Riverside Energy Park, Belvedere

Planning Inspectorate reference: EN010093

Written Representation Summary

Figure 3 – Local heat demand density, all sectors, National Heat Map

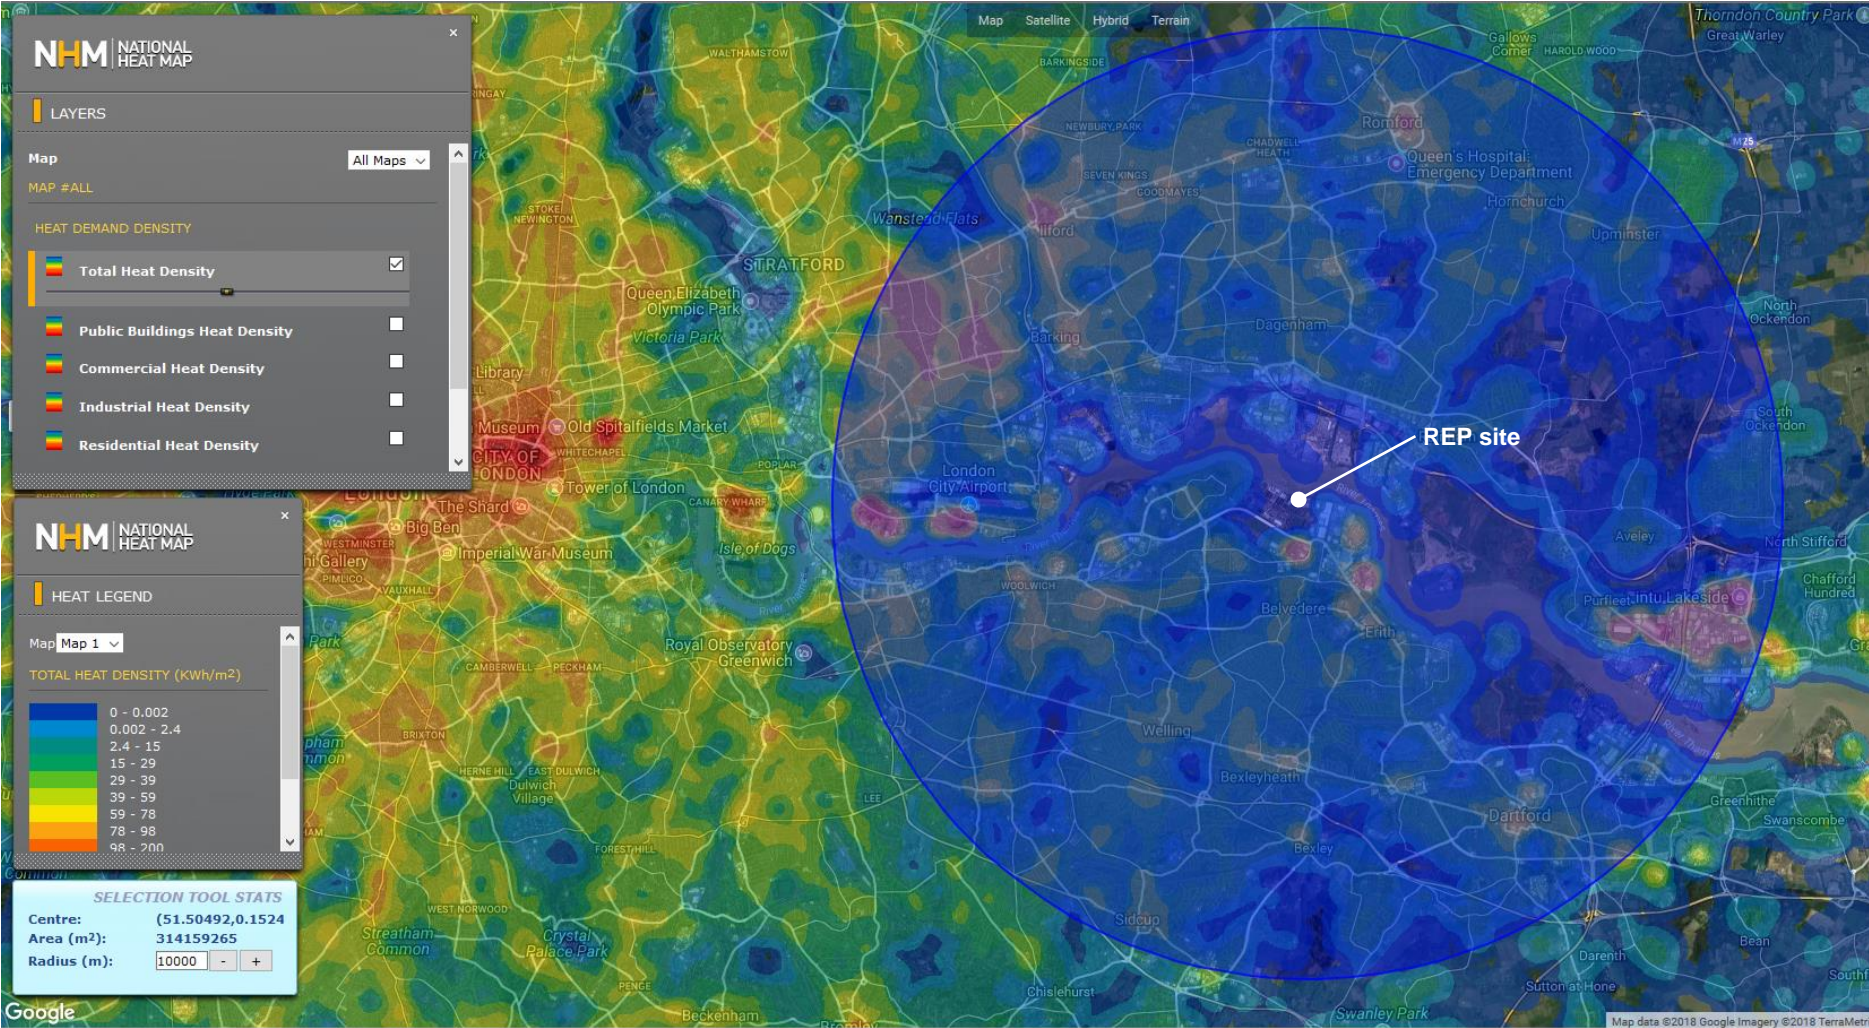
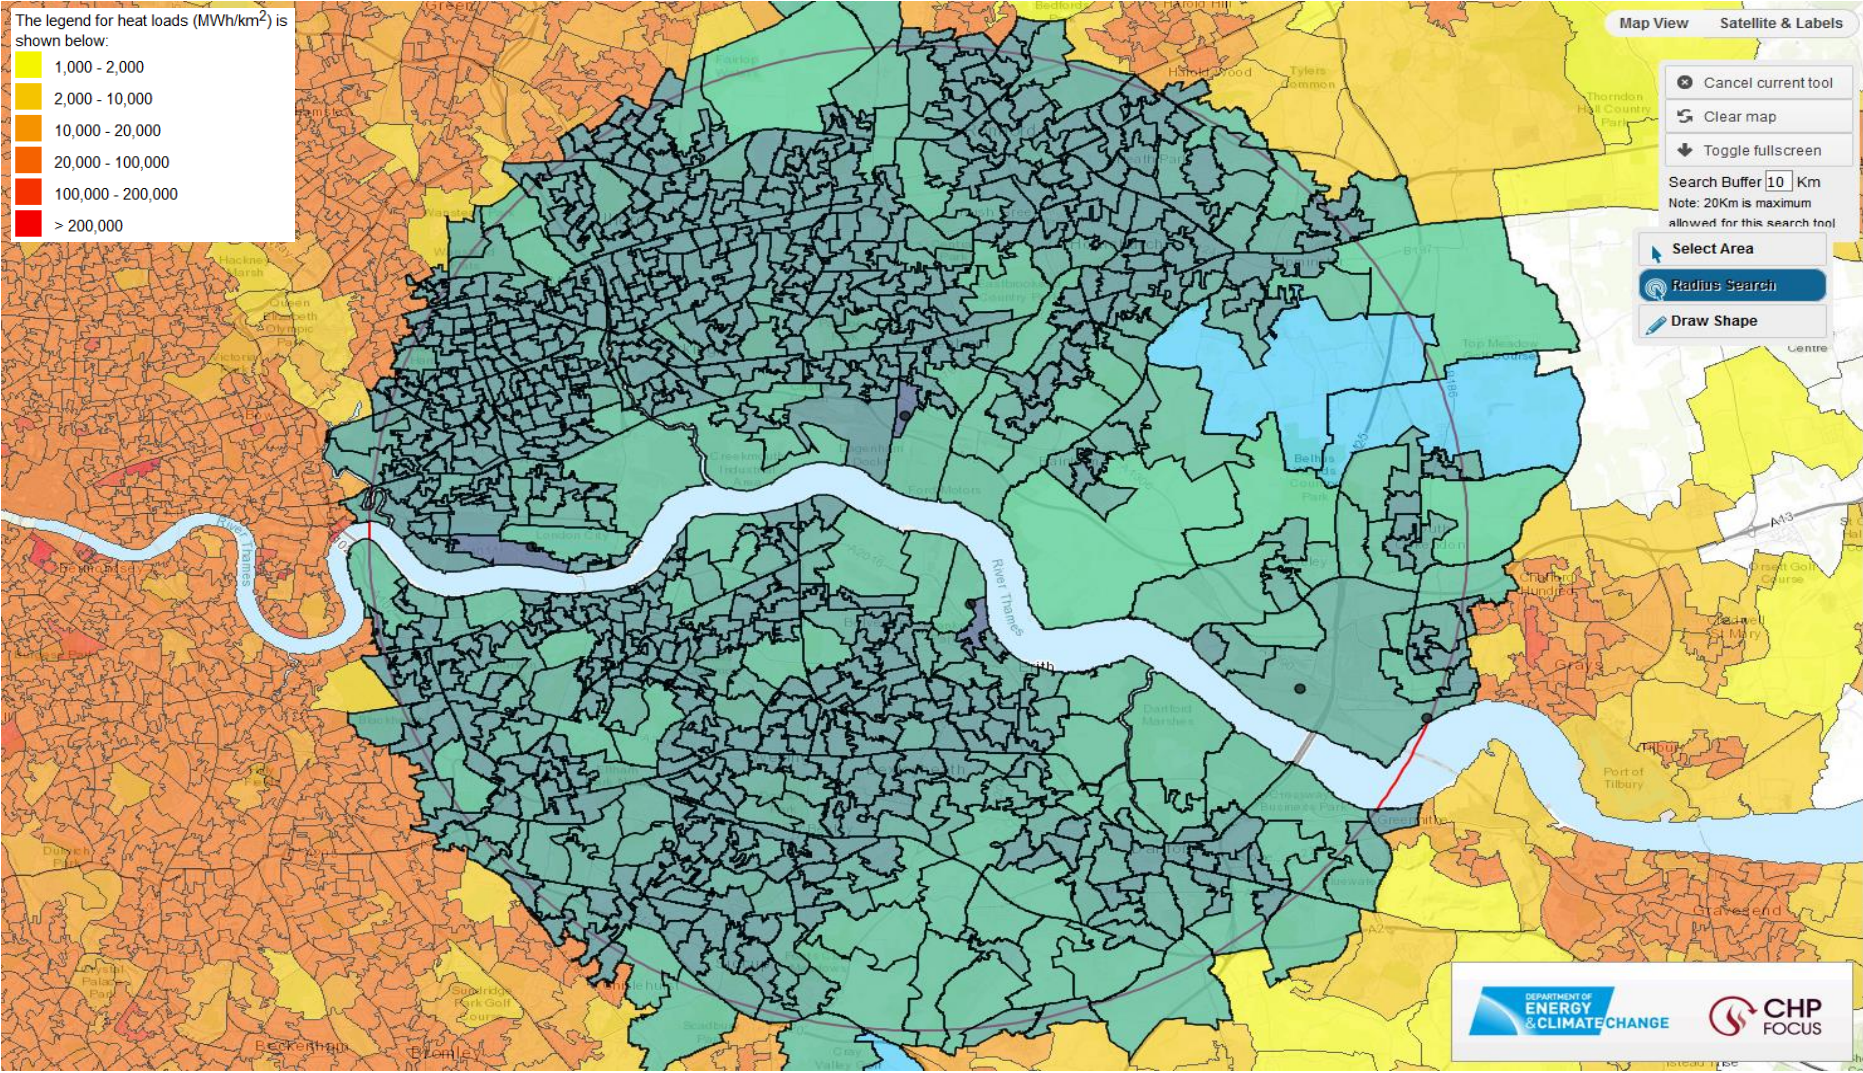
3.1. The GLA's detailed consideration of the REP proposals has concluded that there is insufficient heat demand in the local area for the proposed energy from waste facility known throughout the Applicant's documents as the Energy Recovery Facility (ERF) to operate as an effective CHP plant and that the Applicant overstates the CHP opportunities. The REP would not therefore deliver carbon savings. Furthermore, when operating in power-only mode the ERF would be a carbon producer, and not reducer, thereby slowing down the Government's ambition of transition to a low carbon economy.

3.2. The Applicant's CHP study focuses on heat supply from the proposed ERF and ignores the fact that the existing adjacent Riverside Resource Recovery Facility (RRRF), which is also an energy from waste incinerator, could meet feasible nearby heat demand with only 70% of its heat supply capacity.
